Case Officer: Laura Bell

Applicant: Albion Land

Proposal: 1) Reconfigure the external layout of Unit 5; 2) Elevational changes to Unit 5; 3) Change the roof plan of Unit 5; 4) Elevational changes to Unit 6; 5) Change the roof plan of Unit 6; 6) Repositioning of Personnel Door of Unit 6 (proposed as non-material amendments to 22/01632/REM)

Drawing Title:
RM4 - Soft Landscape Proposals (Sheet 2 of 4)

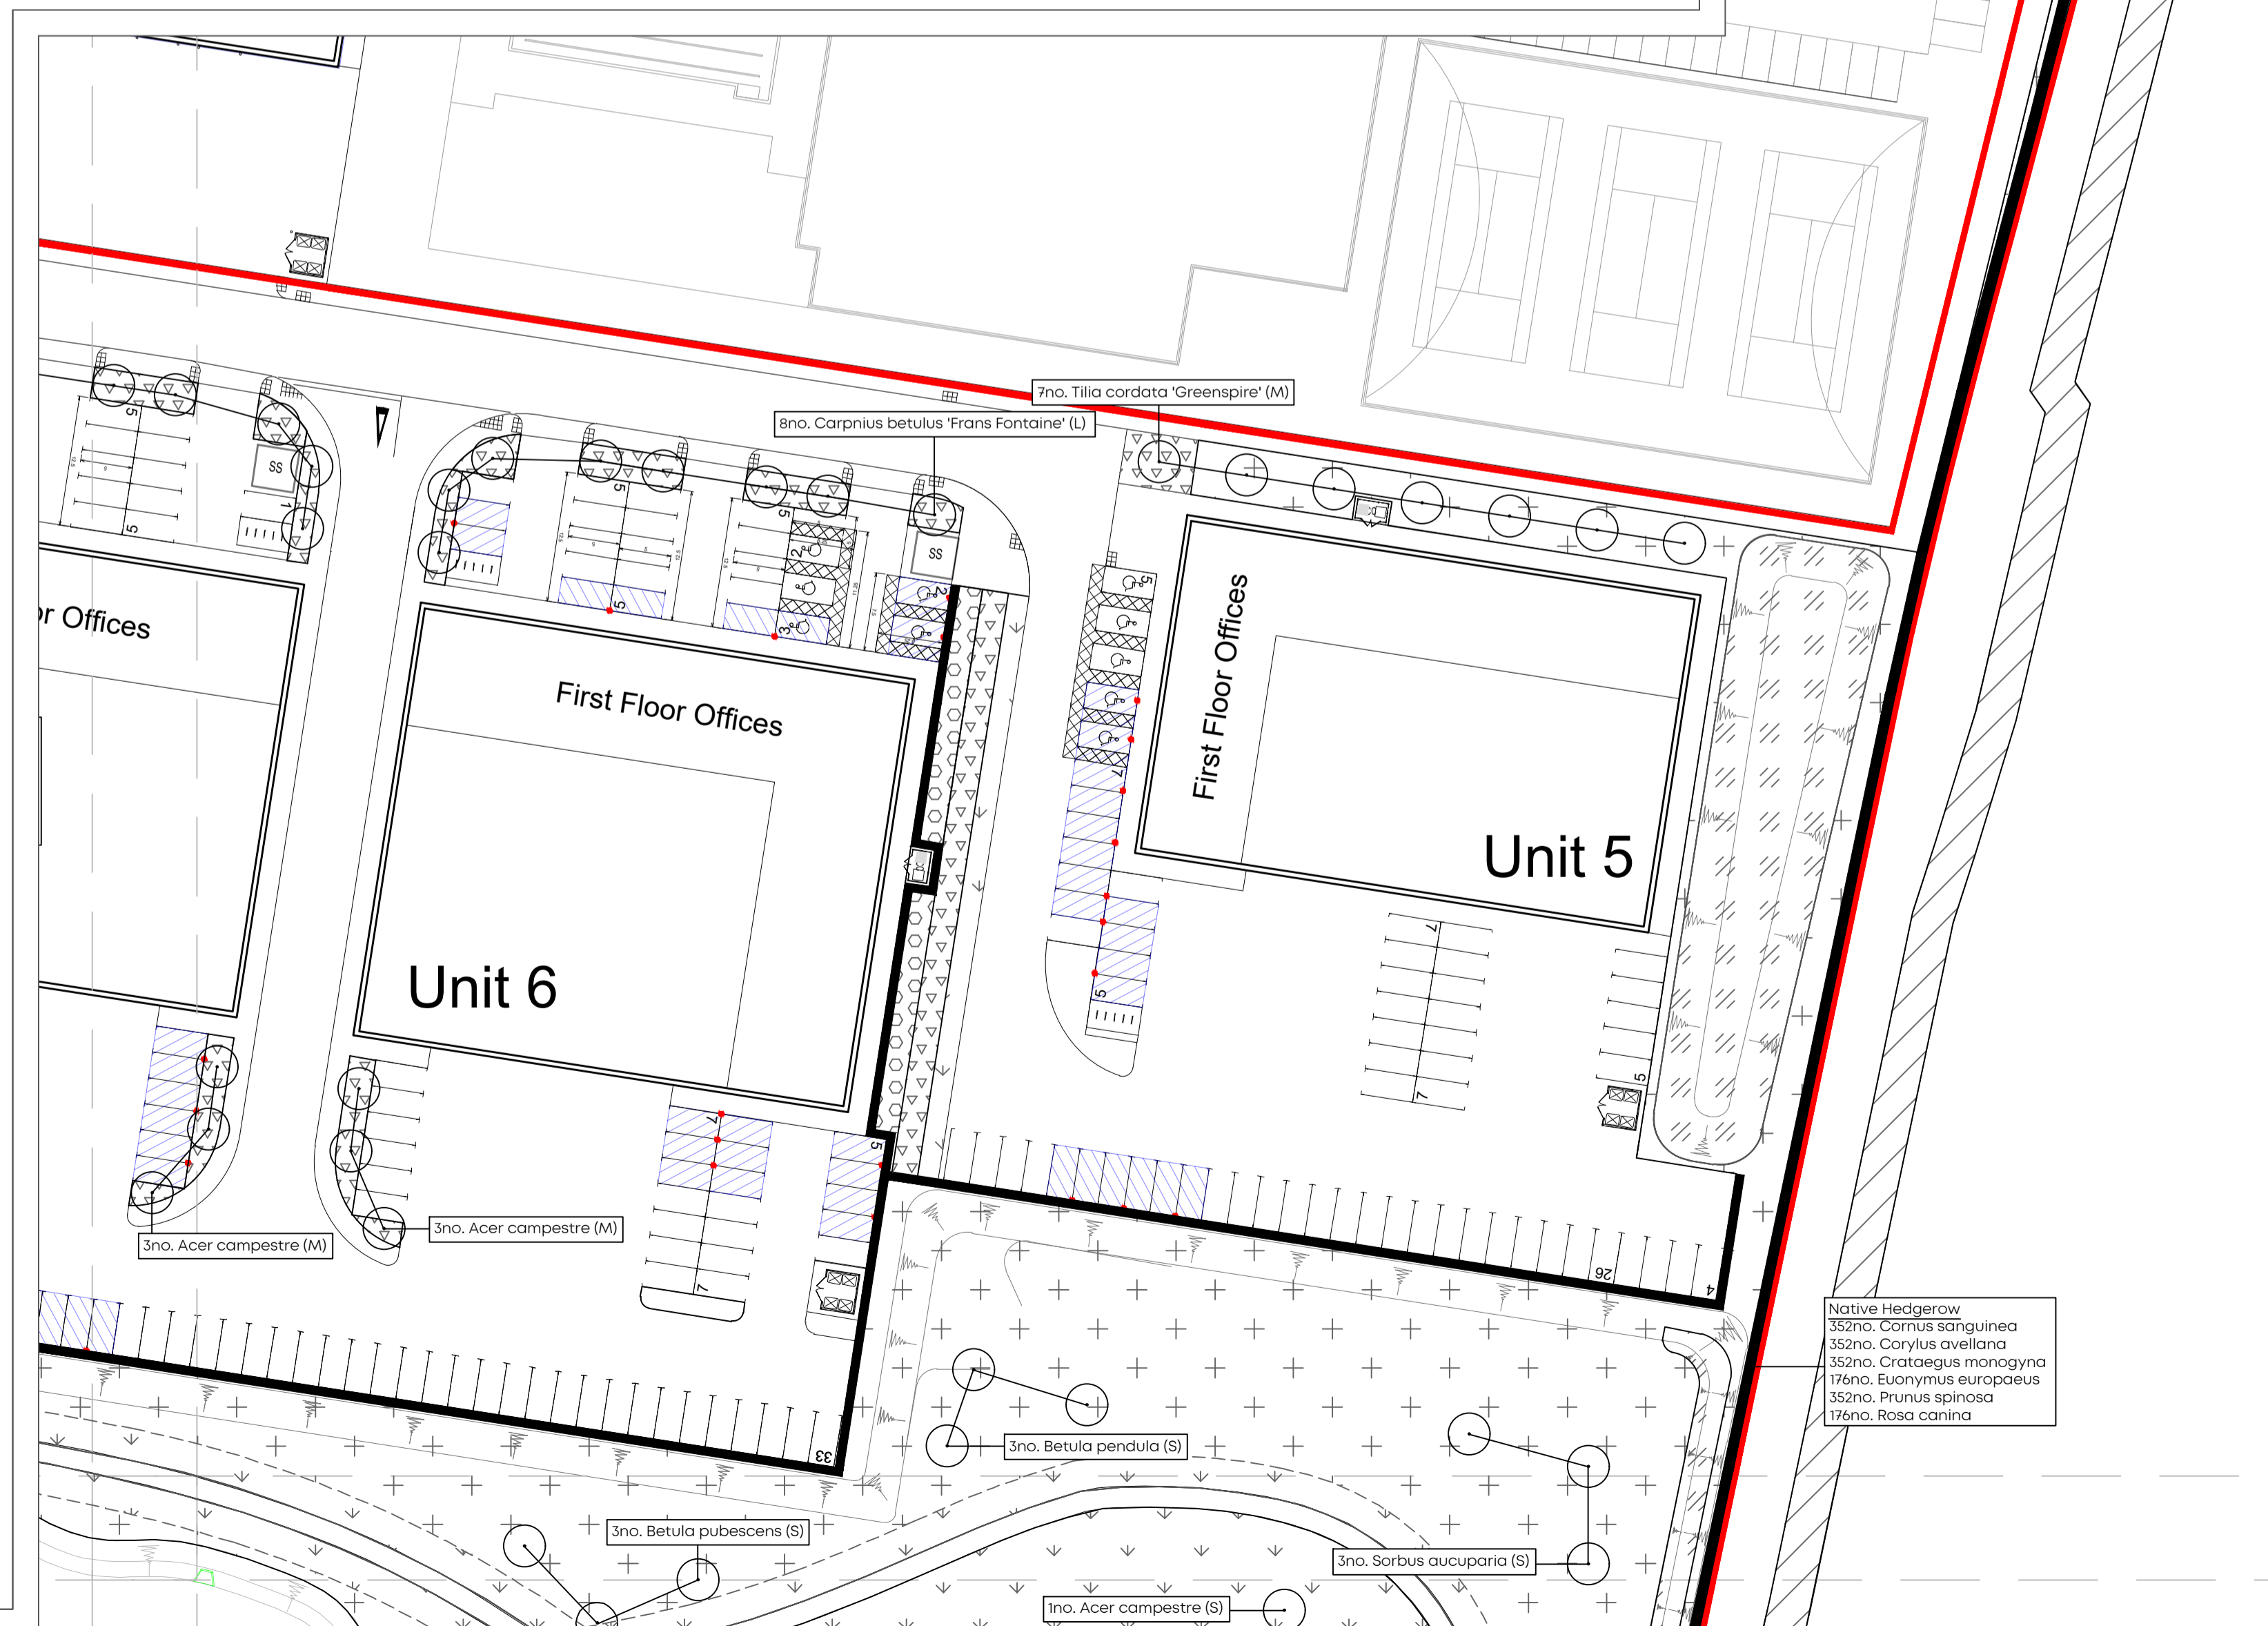
- 5.6. External layout reconfiguration to unit 5 – changes have been made to the layout of car parking, cycle storage location and bin store location, to reflect the re-positioning of the roller shutter doors. The changes do not alter the overall number of parking or cycle spaces. The changes are being sought by varying conditions 1, 2 and 3 of the aforementioned reserved matters.

Drawing Title:
UNIT 6 SECTIONS

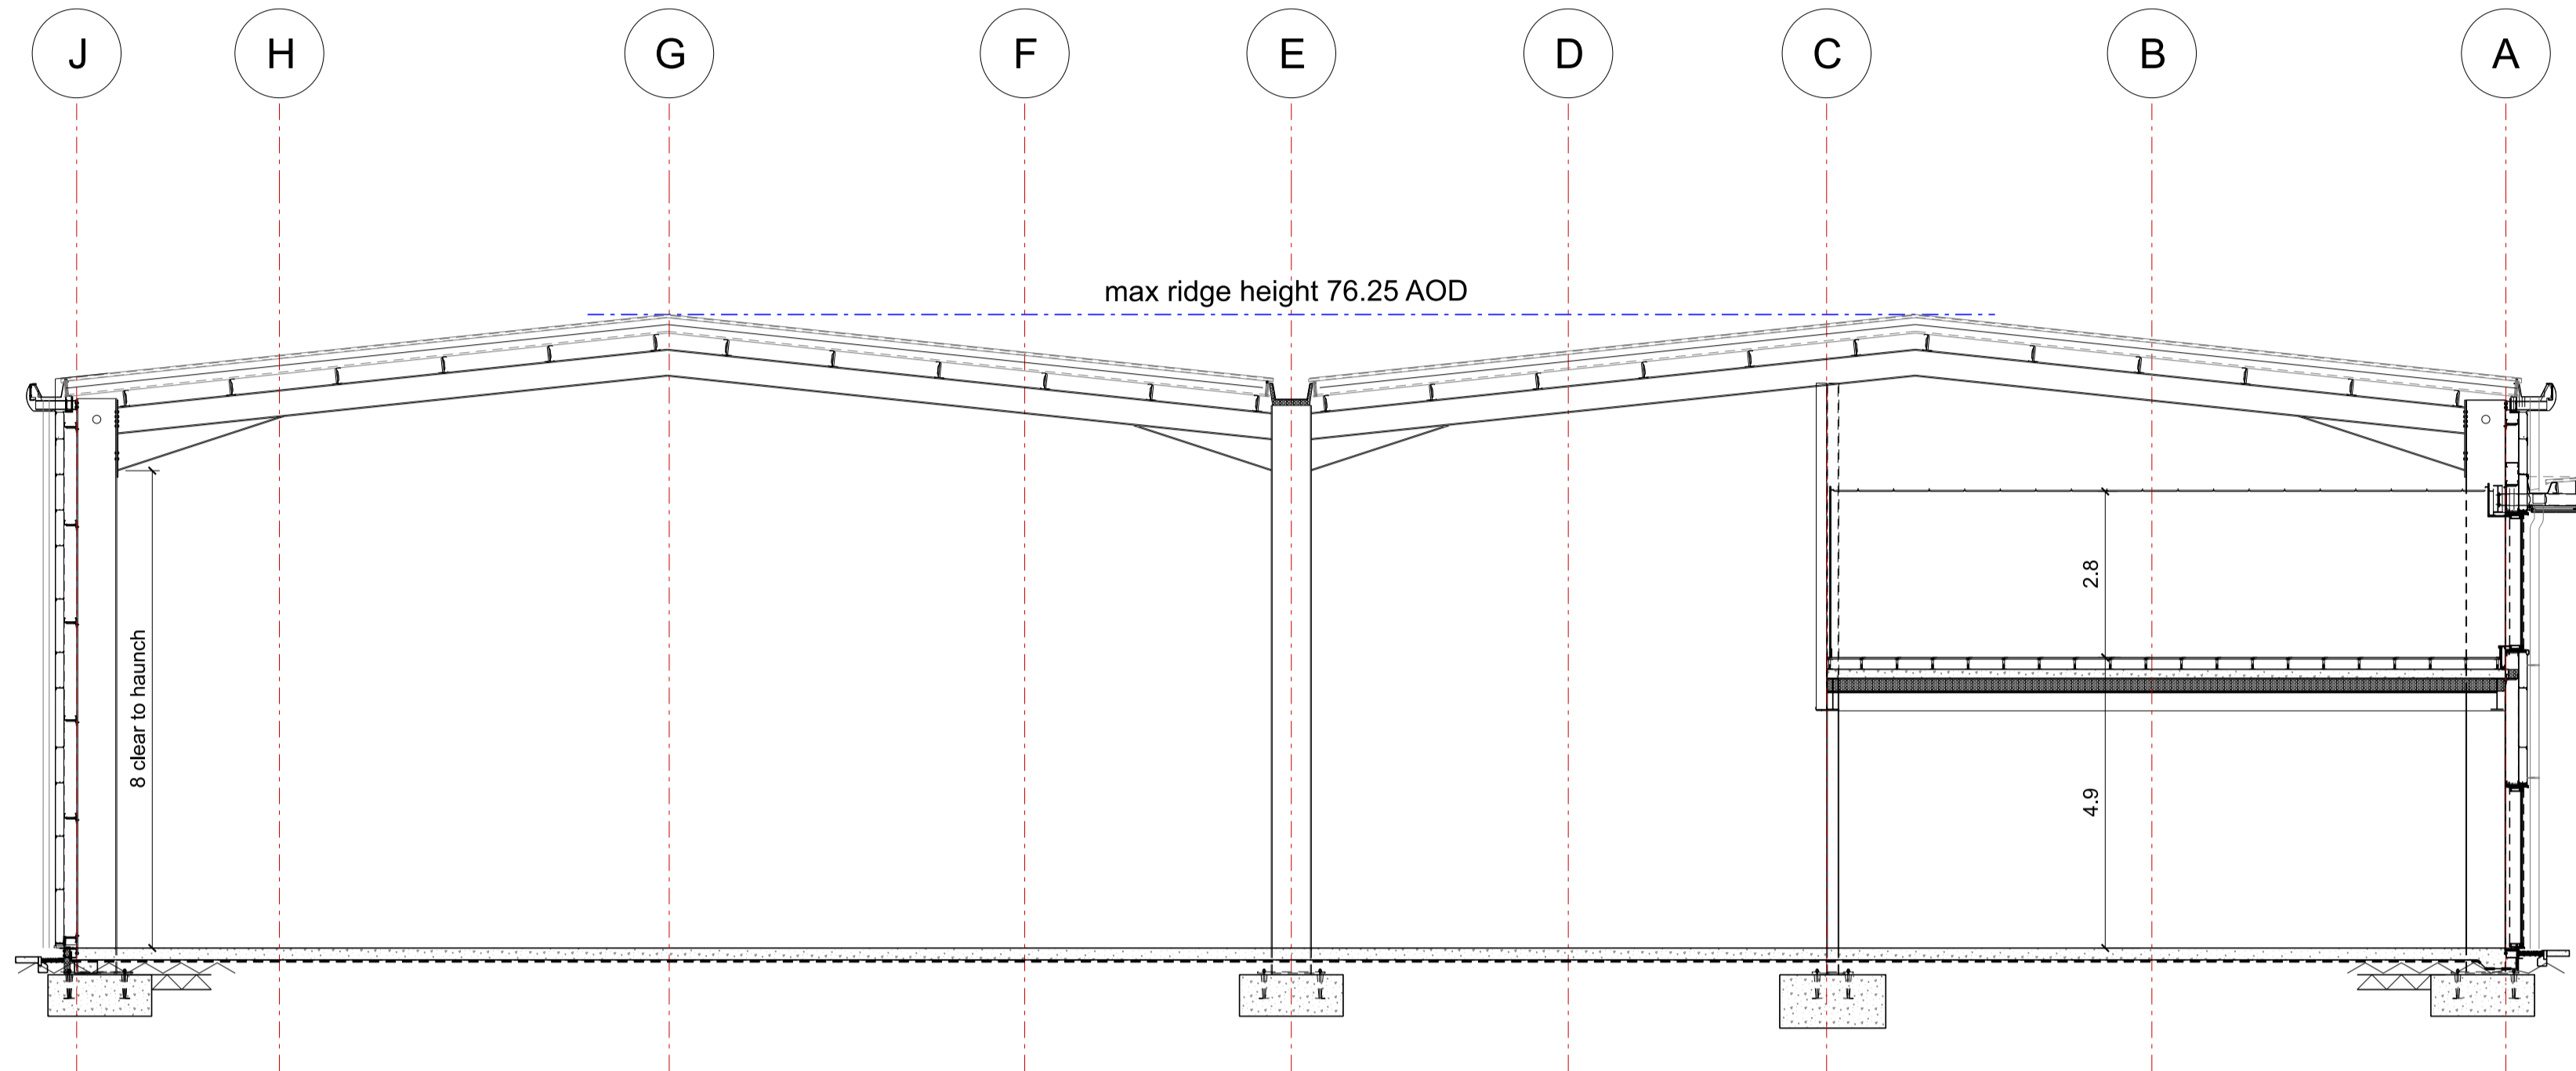
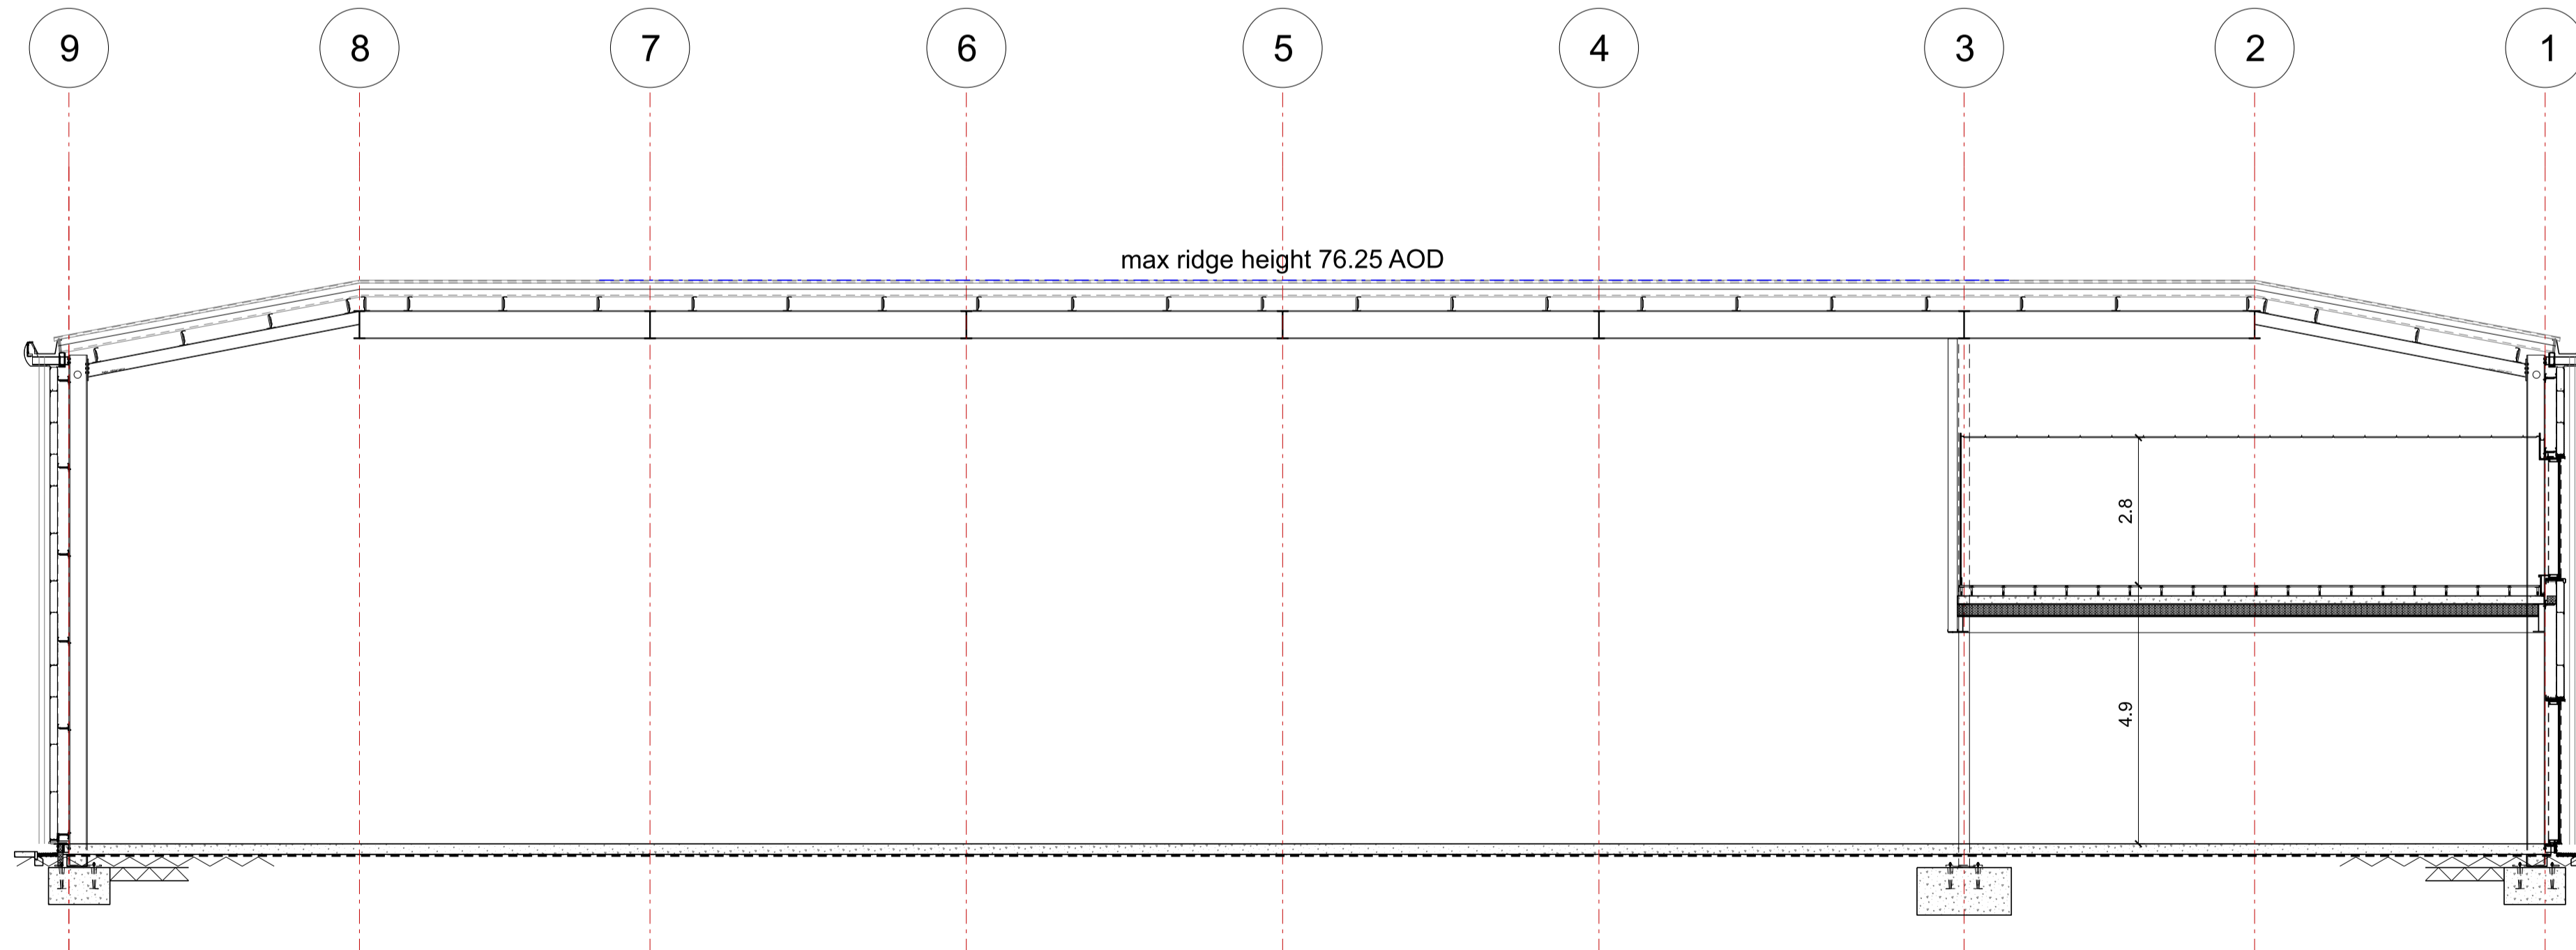
- 5.9. Roof plan alteration to unit 6 – the angle of the hipped roof has been altered (slightly shallower), without any increase in overall ridge height.
